From: [REDACTED]
Sent: 04 December 2024 22:01
To: [REDACTED]; Planning
Subject: Objection 26 Singleton Avenue Read Burnley. Application 3/2024/0658
Attachments: IMG-20241204-WA0005.jpg; IMG-20241204-WA0003.jpg; IMG-20241204-WA0004.jpg; IMG-20241204-WA0002.jpg; Installation guide.eml

Re - Application 3/2024/0658 objection.

This is our formal objection to the planning application of the above property for the retention of the air source heat pump erected within 1m of the boundary and the amended plan dated 27/11/2024 to move the unit and box it in.

Scale 1:50

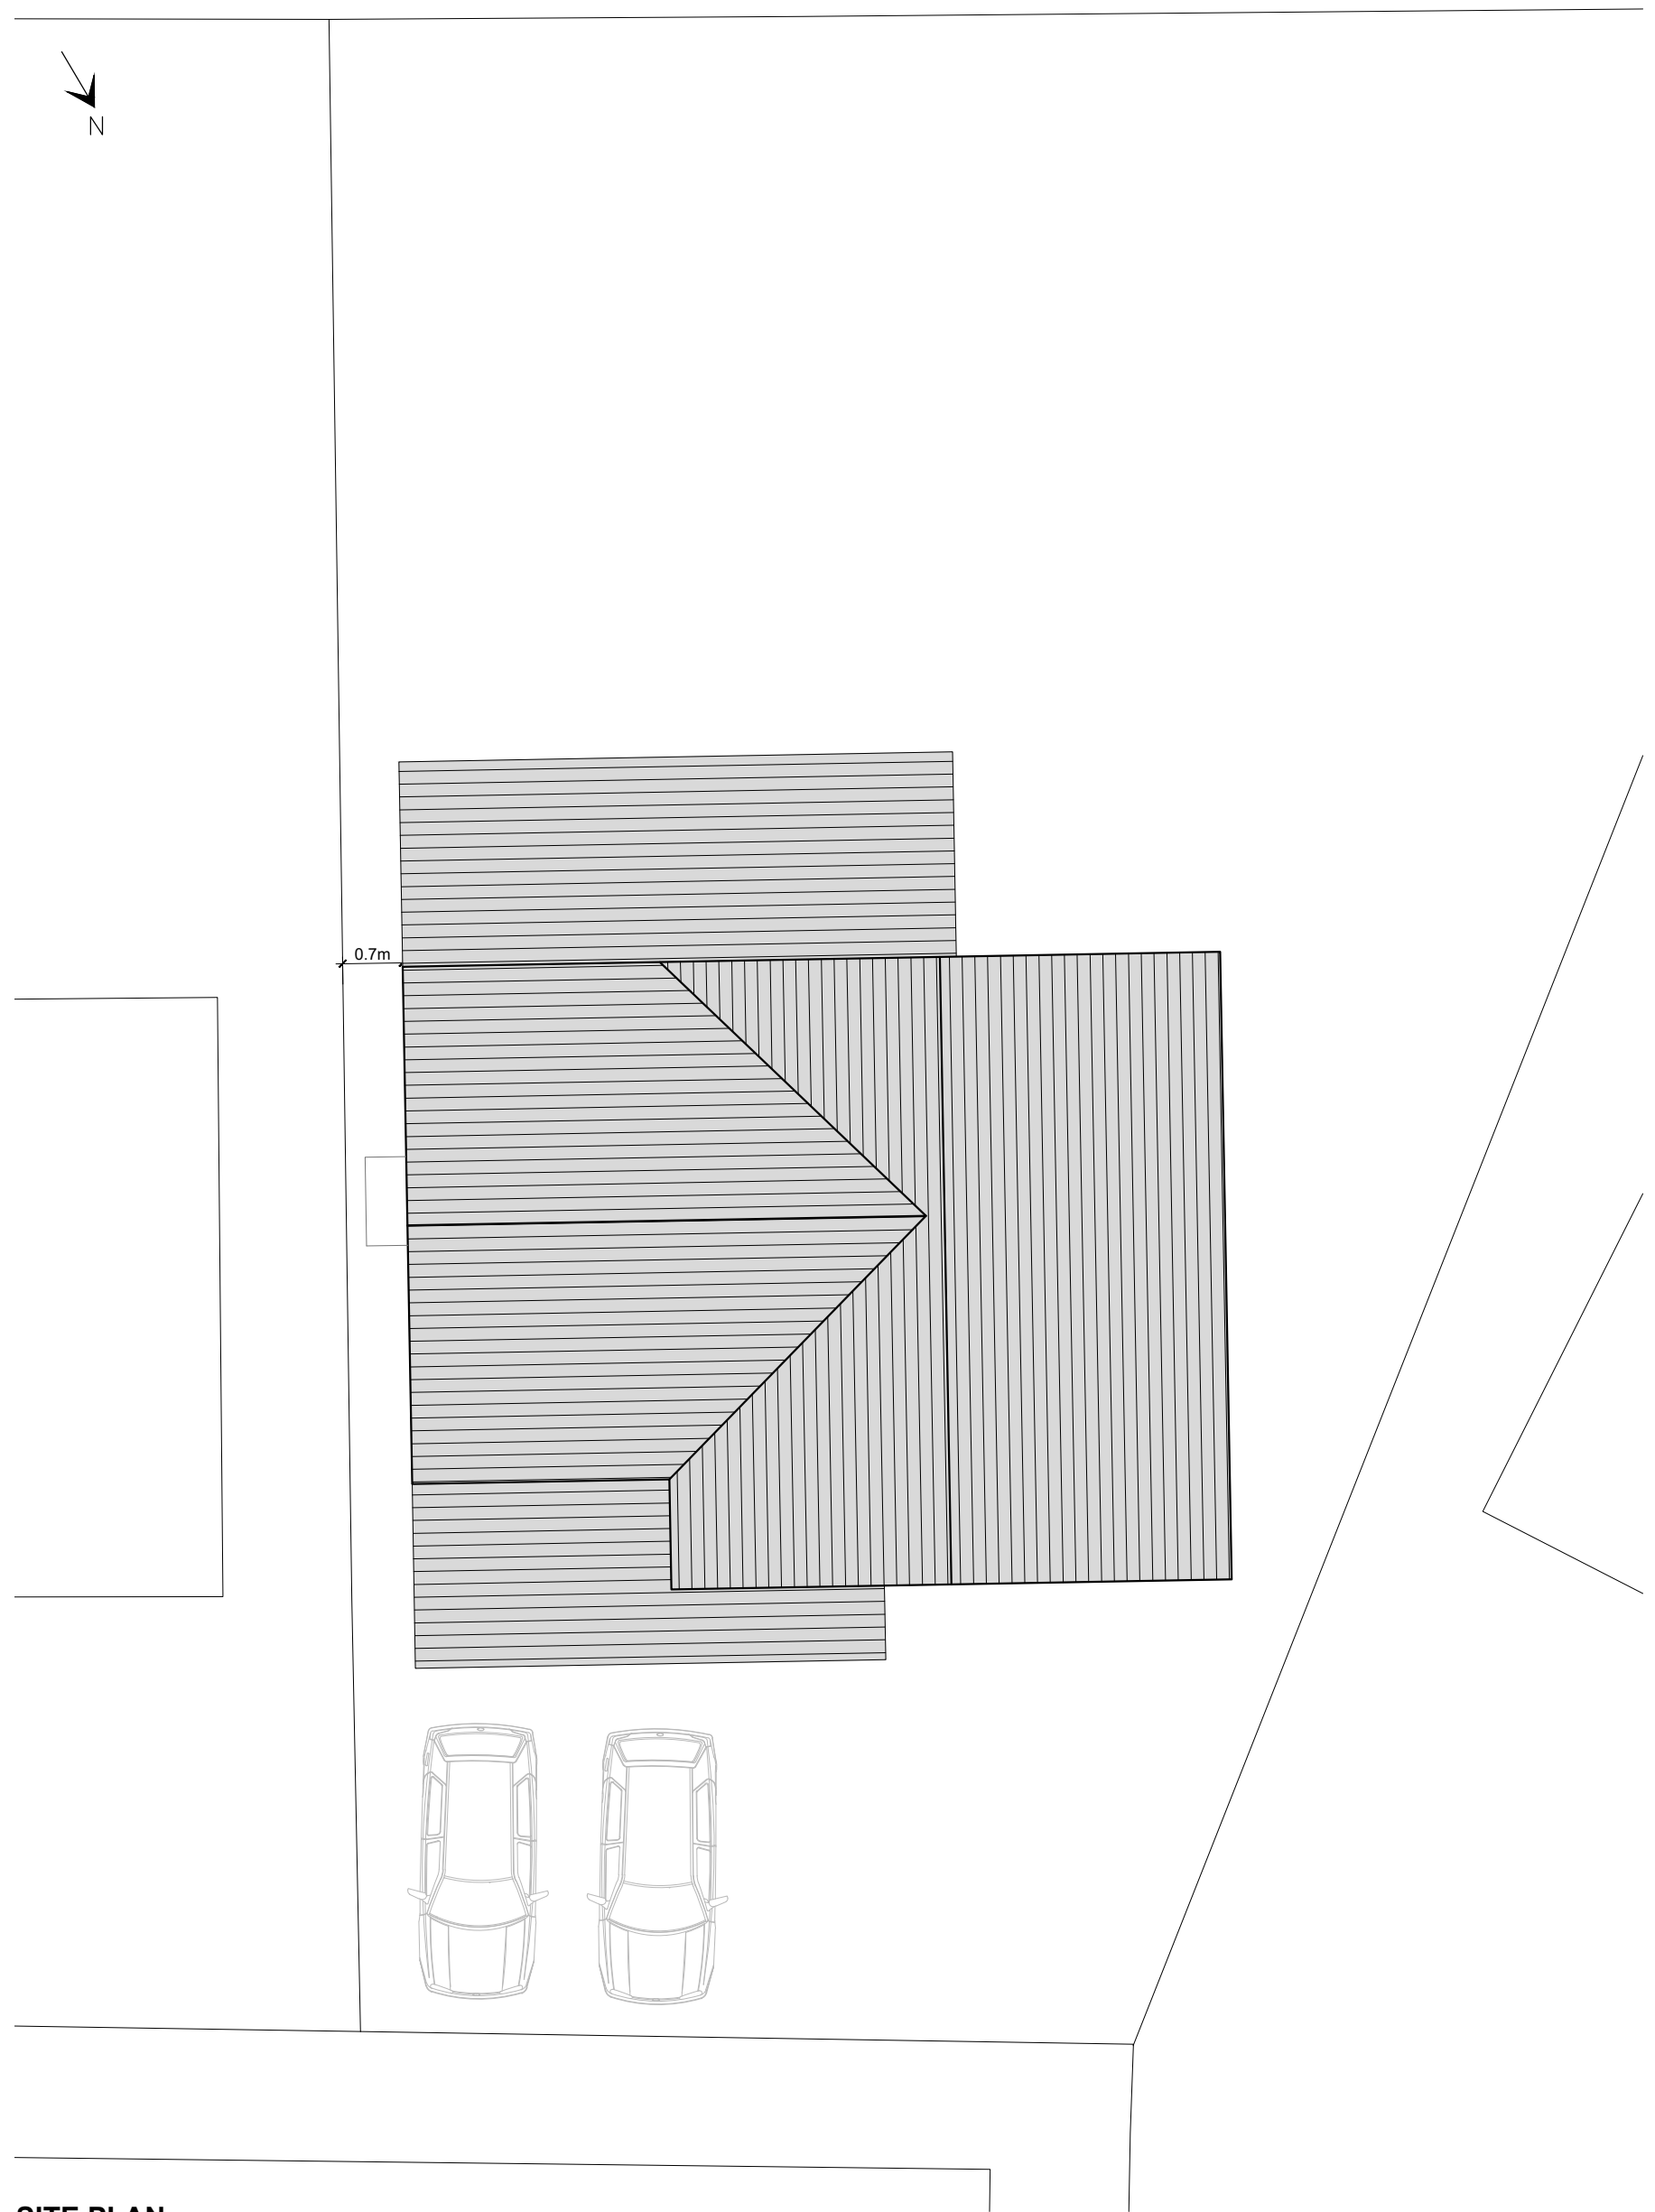
Attached are the manufacturer's instructions for the unit installed at 26 Singleton Avenue. This was obtained directly from [REDACTED] and an email trail can be provided if required. On page 25, it bullet points the installation instructions for the outdoor unit and the first point states that the unit should meet all spatial requirements shown in installation space requirement above. The above diagram gives dimensions for the spatial requirements, 30cm from the left of the unit, 60cm to the right of the unit, 30cm from the wall it is mounted on and 200cm from the front. [REDACTED] feel that the proposed boxing detailed on the plans would contravene the installation instructions for this unit as the space is not available to the front of the unit, nor is there enough room to mount the unit with 30cm of clearance to the rear.

Furthermore, we have attached measurements taken from the wall ([REDACTED]) to the [REDACTED] [REDACTED] The boxing measurement in the proposed plans shows the boxing depth as being 0.6m. As shown on the measurement photographs this would mean the boxing is over the [REDACTED] onto the fence.

This amended proposal does not improve the visual aspect [REDACTED], as this is [REDACTED]

[REDACTED] feel that the amended plans do not go far enough to resolve the situation and also contradict the manufacturer's installation instructions which [REDACTED] feel is a time wasting exercise.
